MEMORANDUM

To: FILE
From: Shukria Wiar
Subject: Application ID: 2017-022
Date: 3/1/2017

Comments Submitted by: Shukria Wiar/Planning on 3/1/2017

CHANGE OF USE (FROM OFFICE TO EDUCATIONAL)  
TOTAL FLOOR AREA 15,573 SF

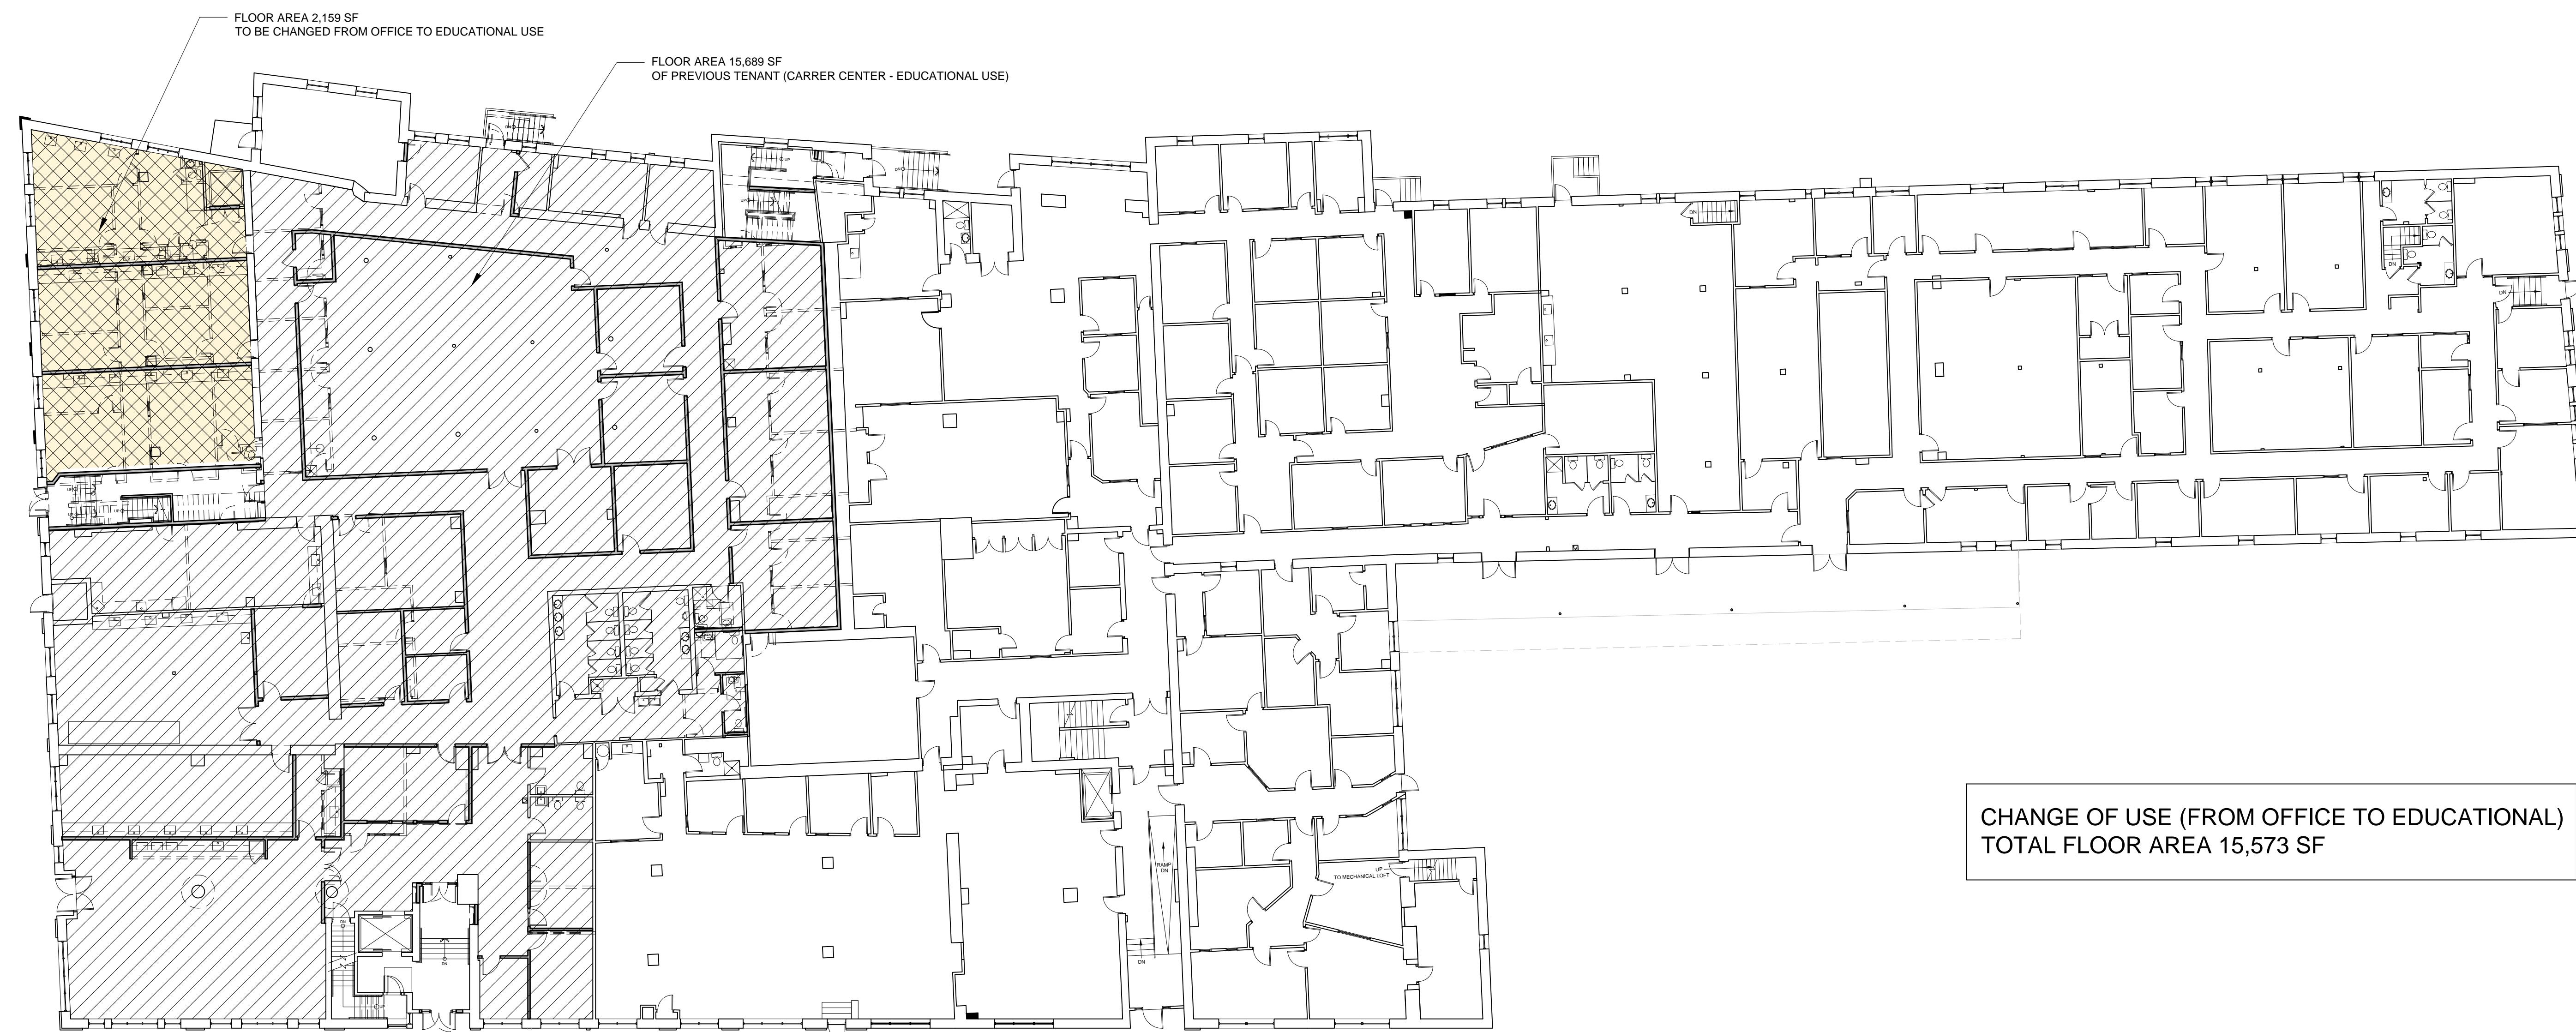
1. Application Update: the application needs to be updated with the correct square footage.
2. B-7 zone performance standards, Section 14-299: these performance standards need to be addressed since it is part of the zoning standard.

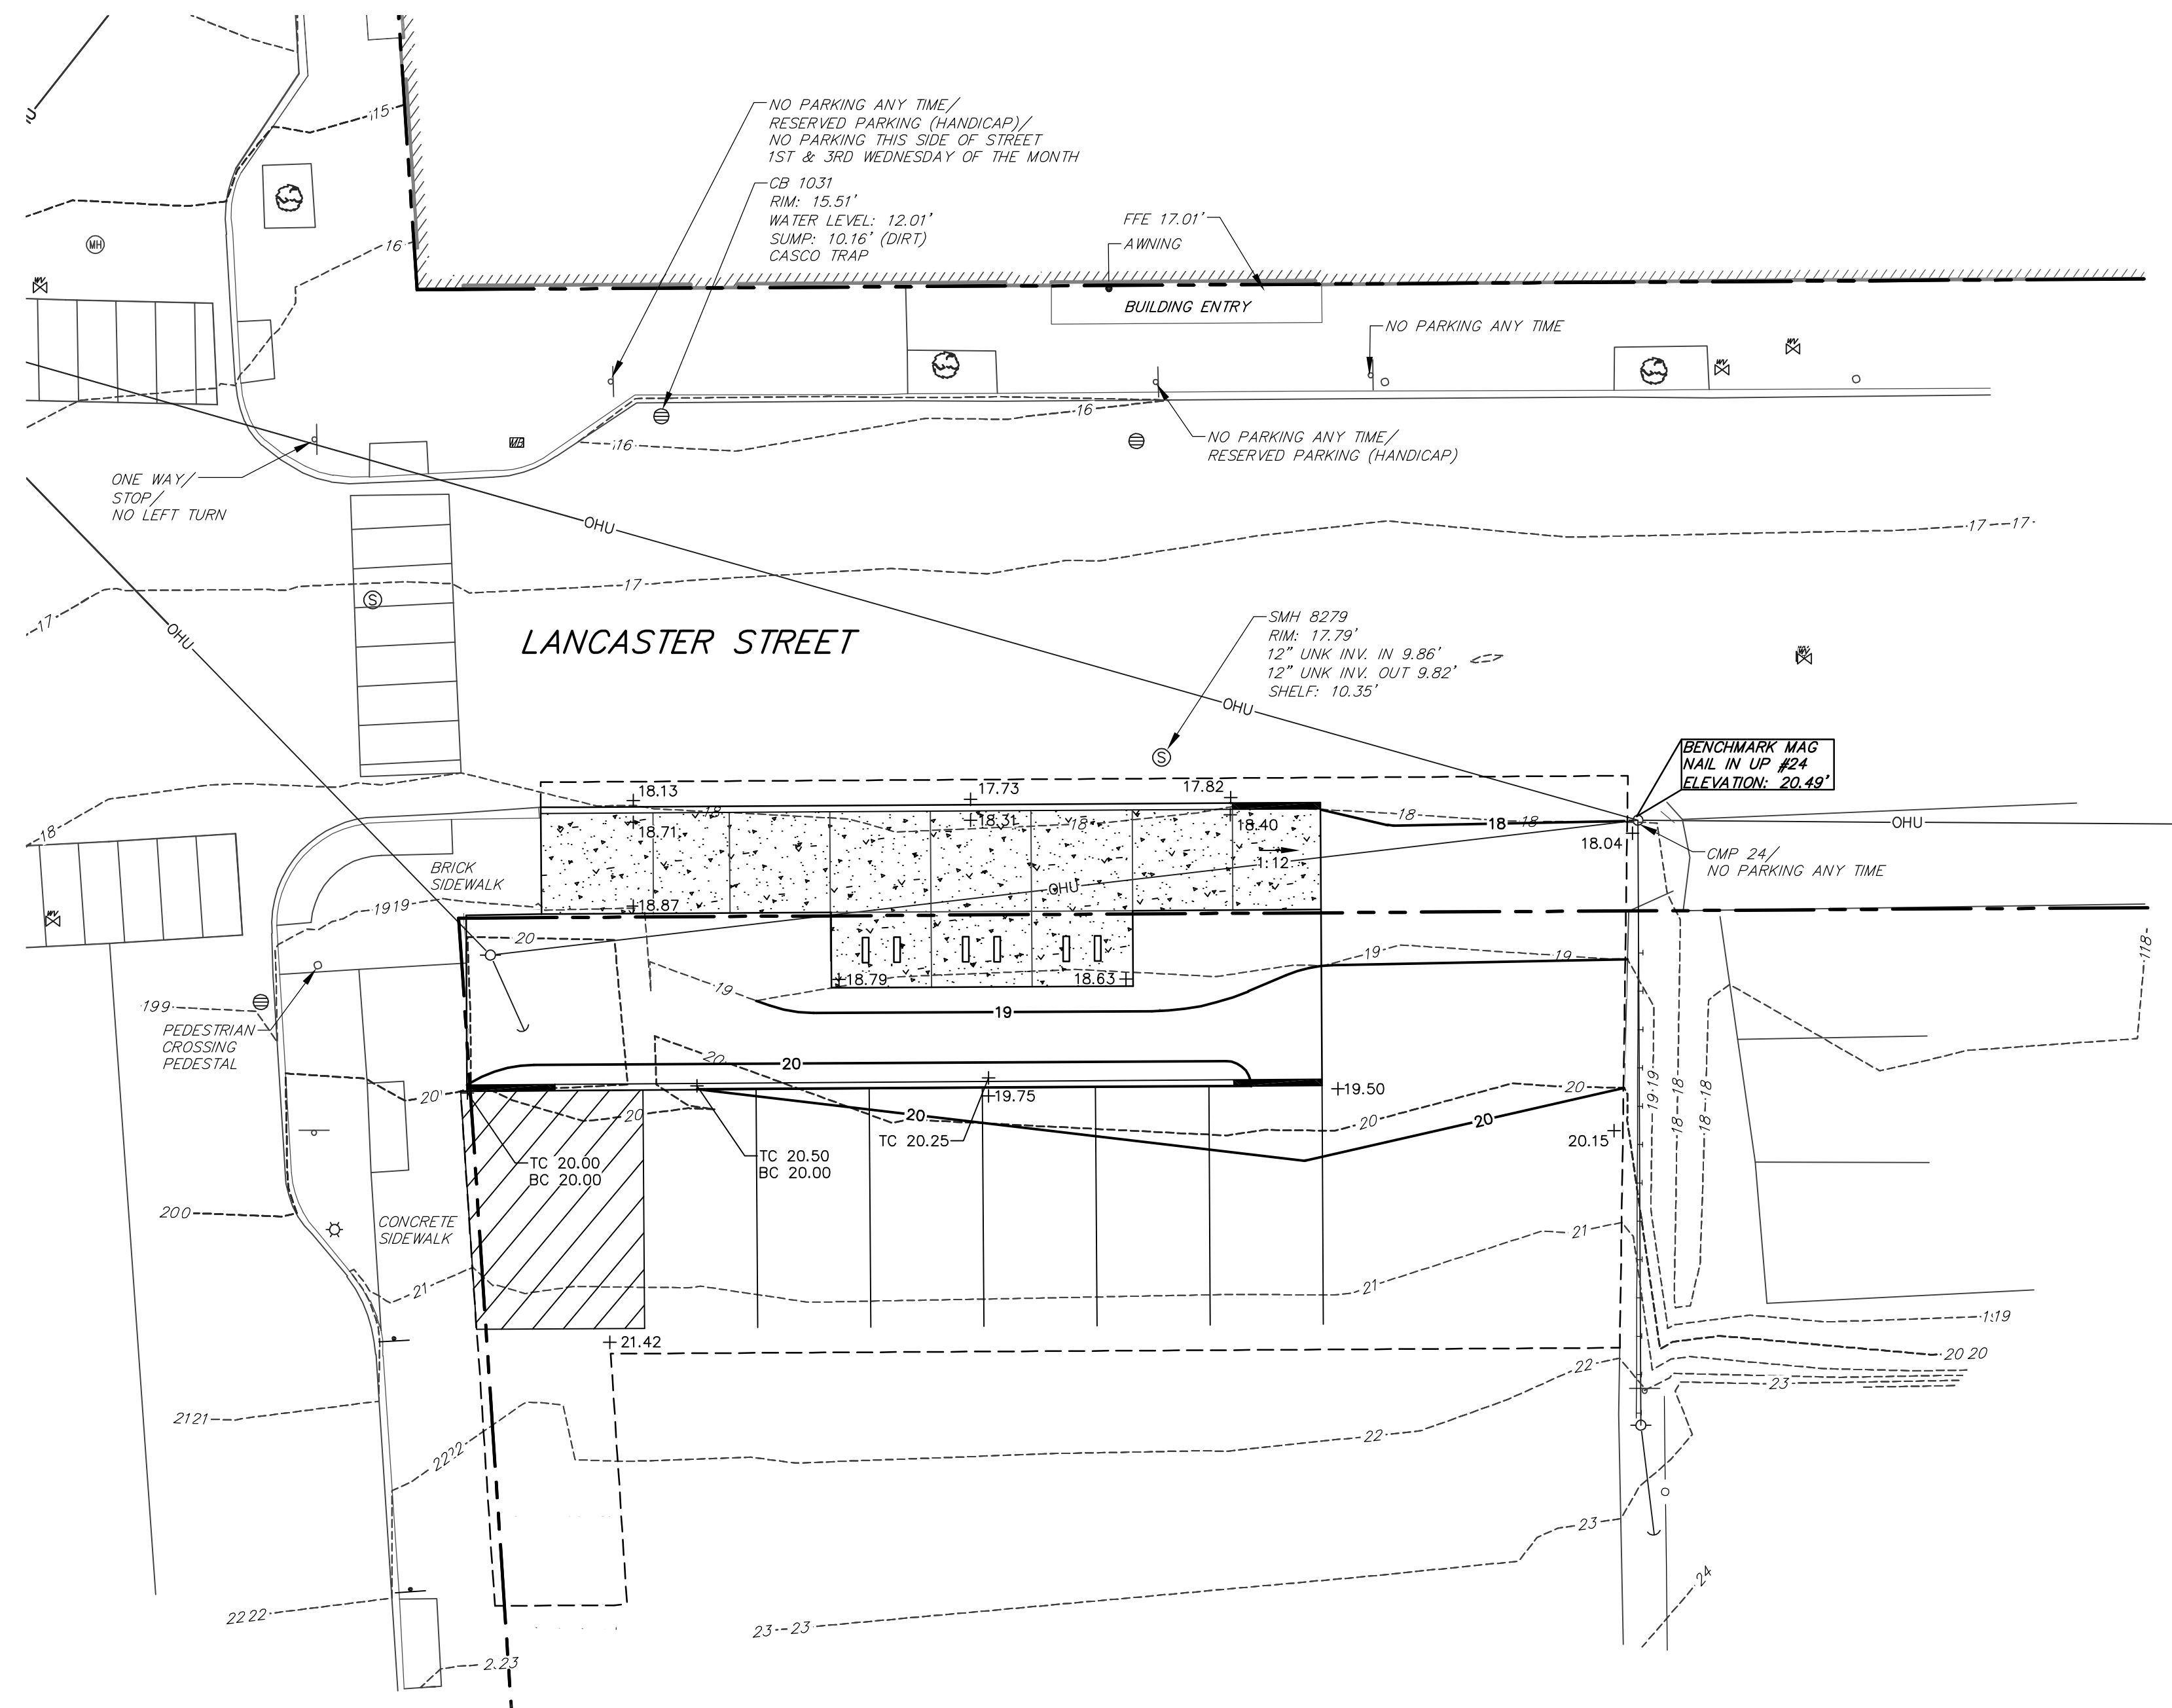
2. The Applicant should provide additional detail pertaining to stairway upgrades along the northwestern side of the building on Kennebec Street. Specifically, will any regrading or pavement replacement be required? The area appears to be close to the right-of-way, and potential impacts due to construction should be reflected. A site plan should reflect any of these changes or impacts.
